Date: 15-Oct-2024
Our Ref: 2024/92111

**TOWN AND COUNTRY PLANNING ACT 1990
TOWN AND COUNTRY PLANNING (GENERAL PERMITTED DEVELOPMENT)
(ENGLAND) ORDER 2015
NOTIFICATION OF PROPOSED CHANGE OF USE AND BUILDING OPERATIONS
APPLICATION NUMBER: 2024/92111
AT: land opp, 104, Wakefield Road, Lepton, Huddersfield, HD8 0EA**

Prior notification for change of use from agricultural building to one dwelling

Drawing Title:
Ground Floor Plan
As Existing

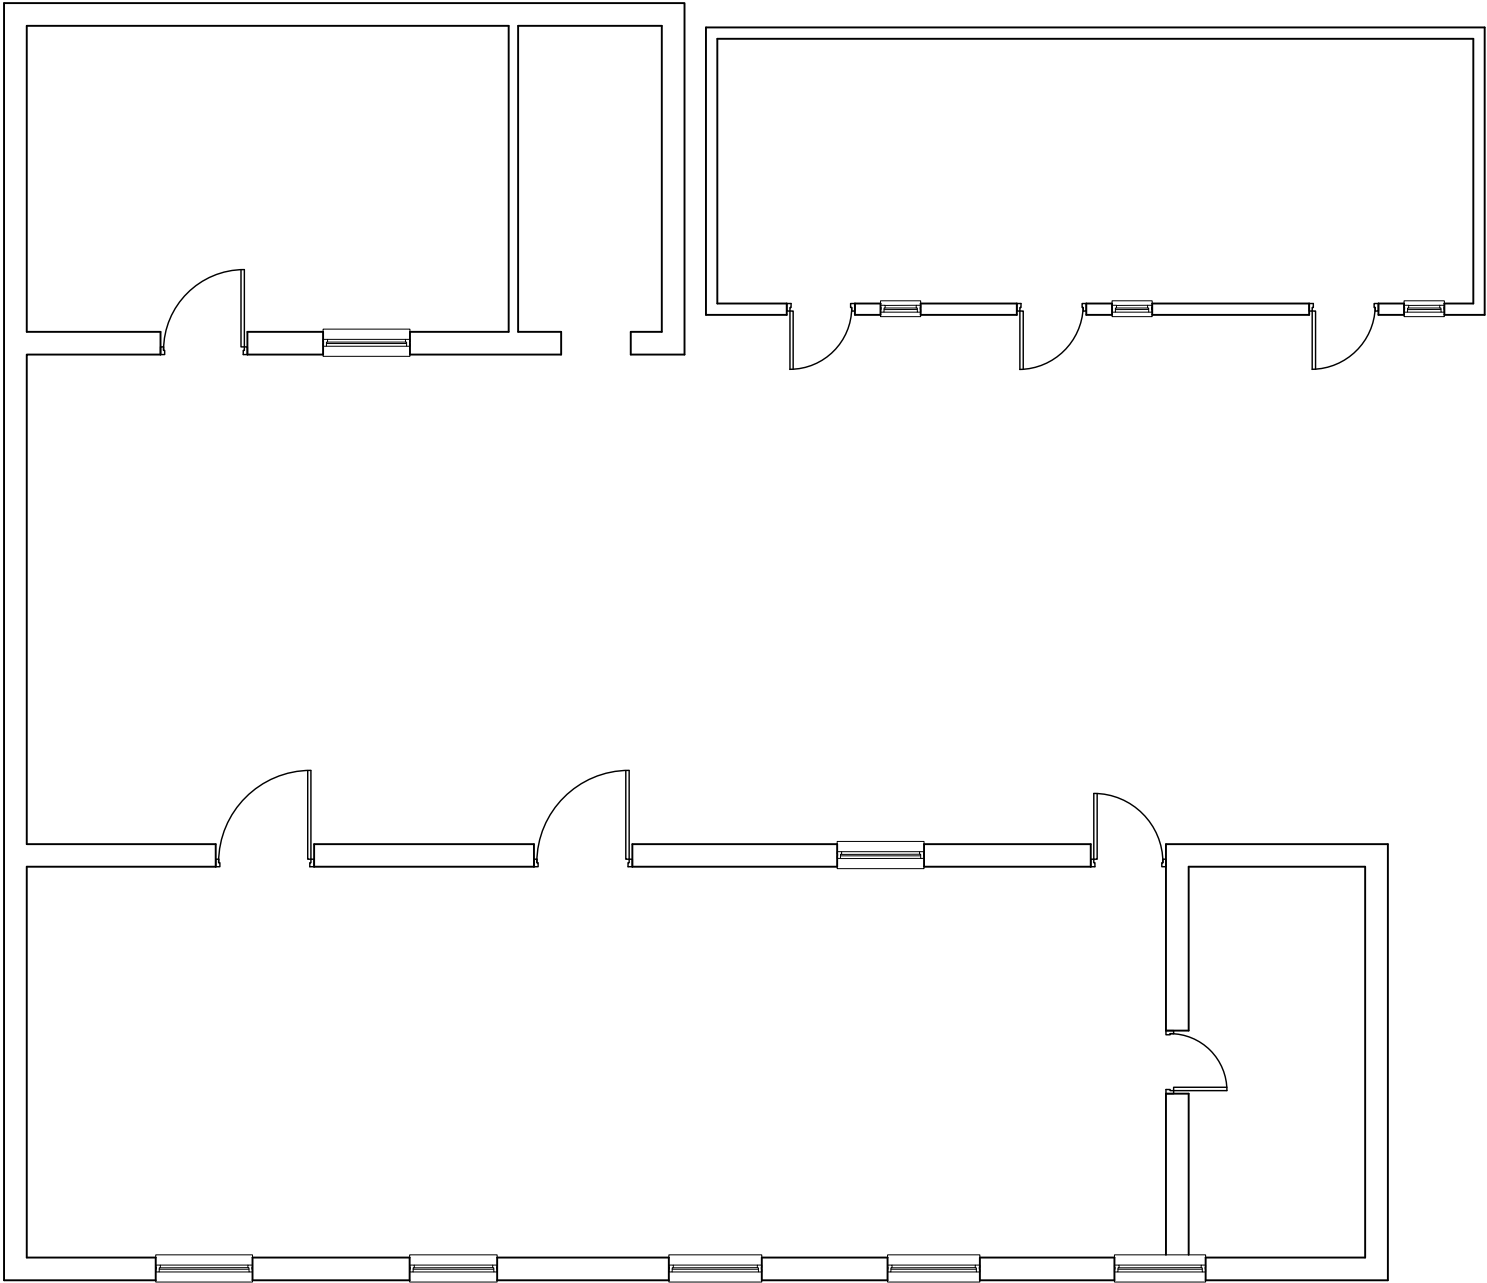
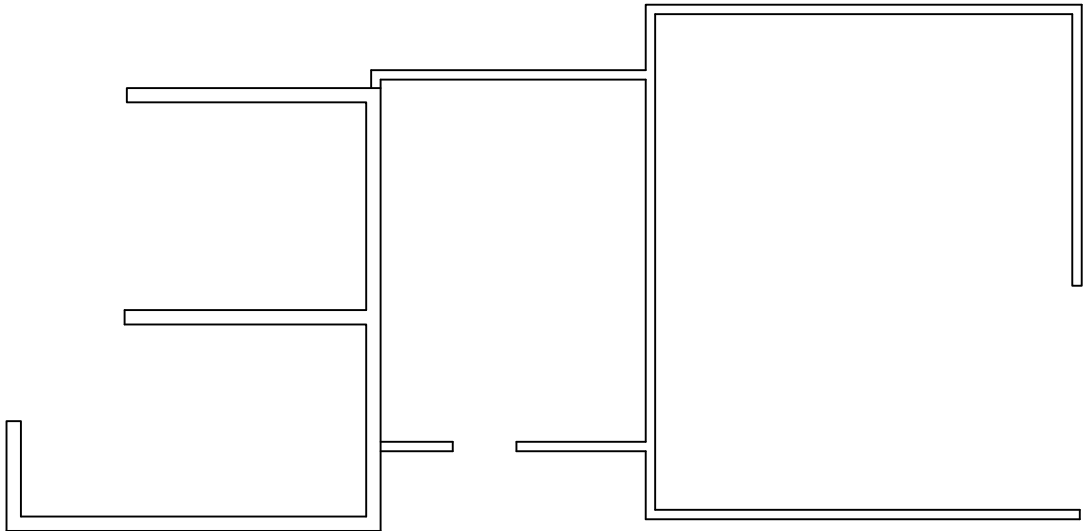
1. The proposed alterations to the design and structure of the buildings would be so extensive to be within the reasonable definition of "conversion". The proposed development therefore does not benefit from permitted development rights under the provisions of Part 3, Class Q of Schedule 2 of the Town and Country Planning (General Permitted Development) (England) Order 2015 (as amended).

Drawing Title:
Ground Floor Plan
As Proposed
Scale: Date: Drawn: Checked:
1:100 @ A3 May 24 TC
Drawing Number: Revision:
006

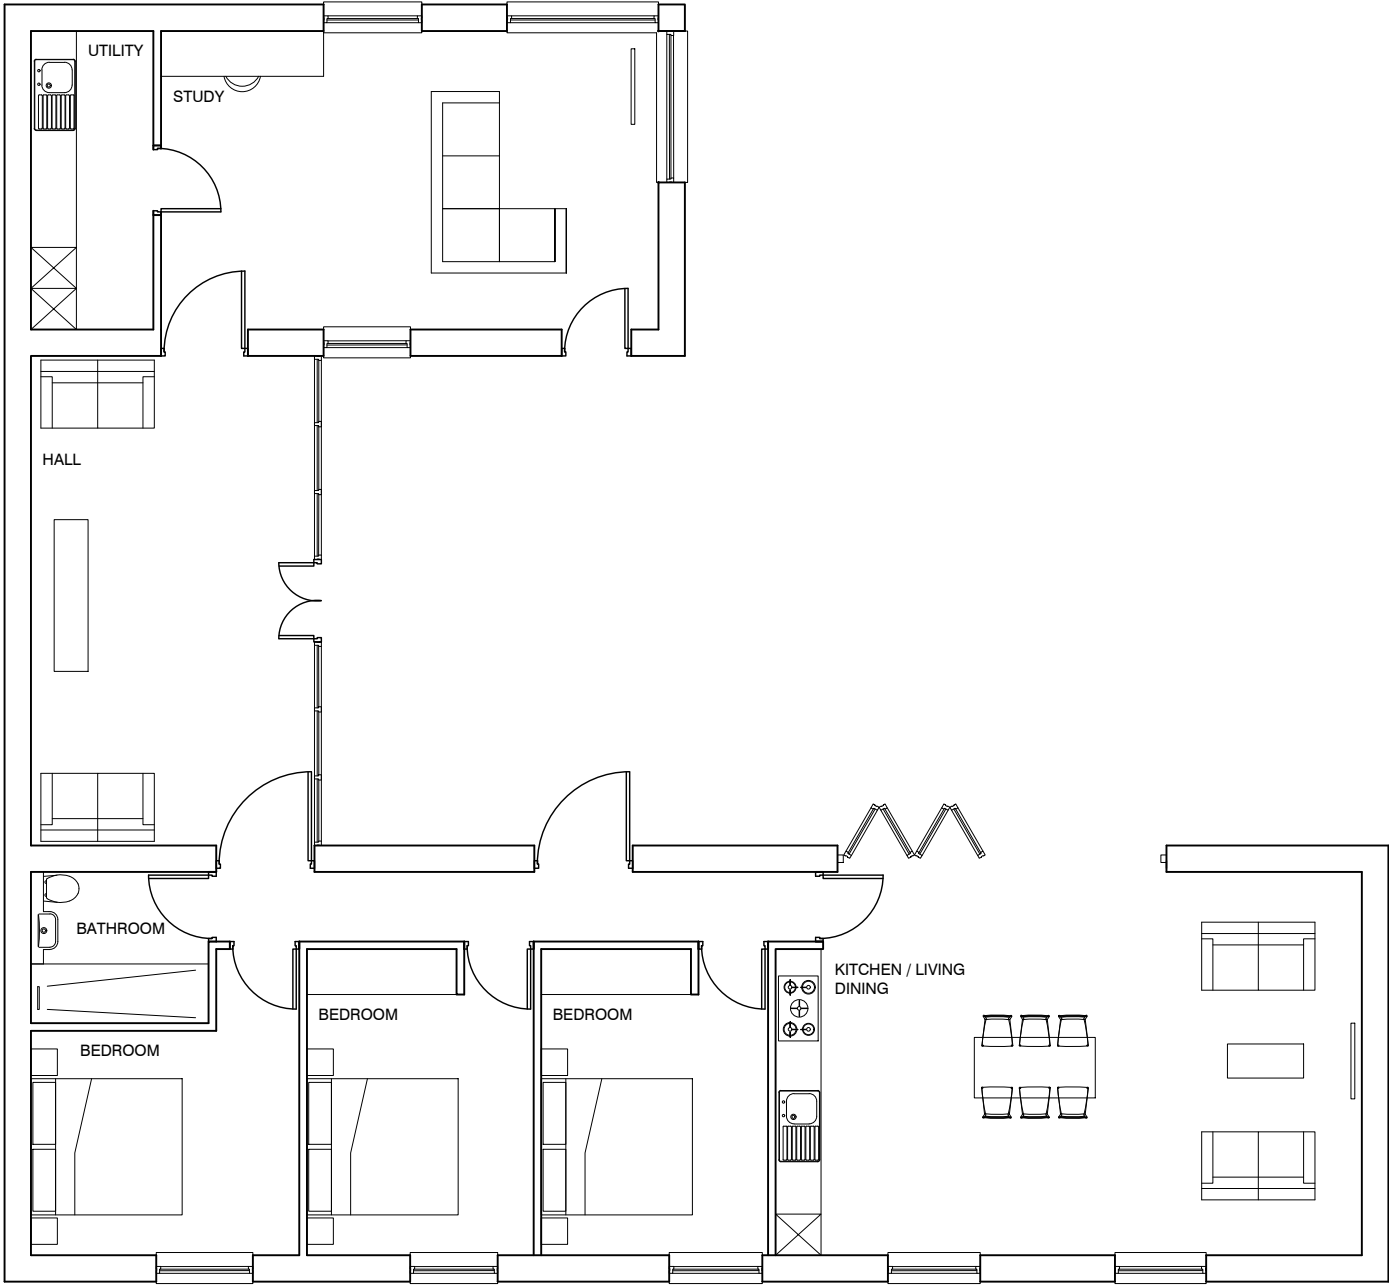
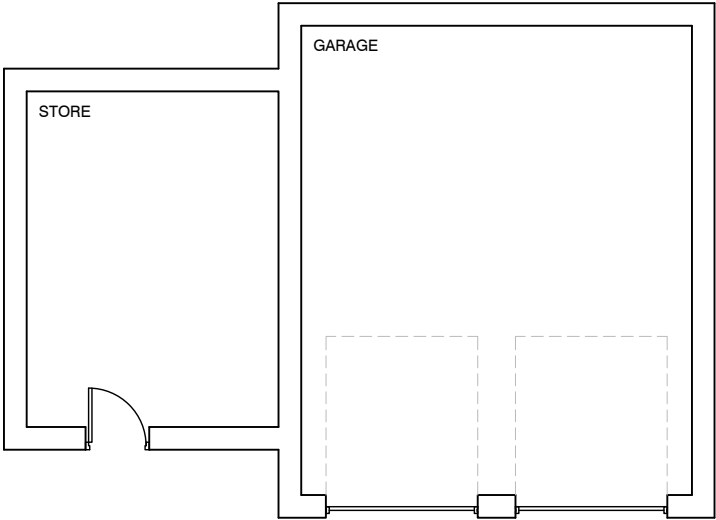
2. The proposed change of use would result in a new dwellinghouse, including the proposed domestic garage/store, exceeding 150 square metres contrary to sub-paragraph Q.1(c) of Part 3, Class Q, Schedule 2 of the Town and Country Planning (General Permitted Development) (England) Order 2015 (as amended).

3. The external dimensions of the proposed building would, in places, extend 0.2 metres beyond the external dimensions of the existing building contrary to sub-paragraph Q.1(h) of Part 3, Class Q, Schedule 2 of the Town and Country Planning (General Permitted Development) (England) Order 2015 (as amended).
